Our Ref CES01234
Contact Devinda Kumarasinghe

19 December 2012

DUBBO BASE HOSPITAL REDEVELOPMENT

1	19/12/12	Bus 12.5m Swept Path		KD	OK
Rev	Date	Description		Drawn	Appr:

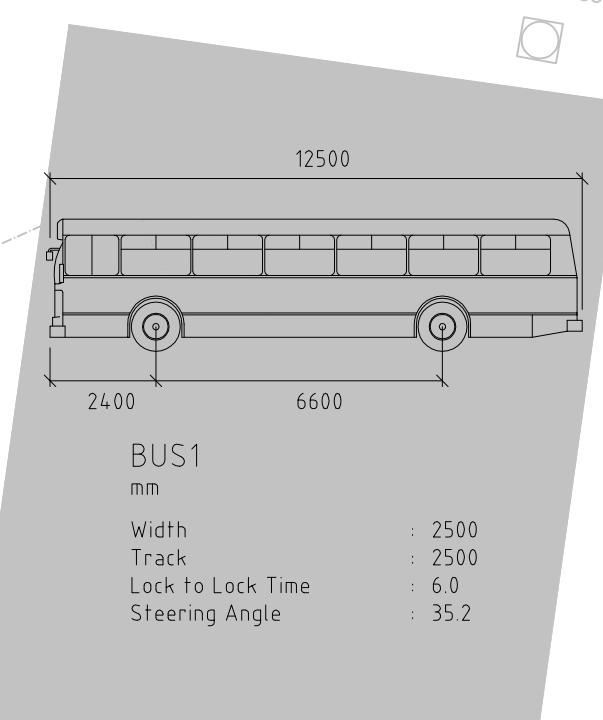
- The internal roadways have insufficient width to accommodate the required bus movements into and out of the site.
- A preliminary swept path analysis of a 12.5 metre bus travelling along the potential loop has been undertaken and is shown in the attached plan. The plan assists in illustrating the potential issues raised above in terms of insufficient roadway width and conflict with emergency and pick-up / drop-off vehicles
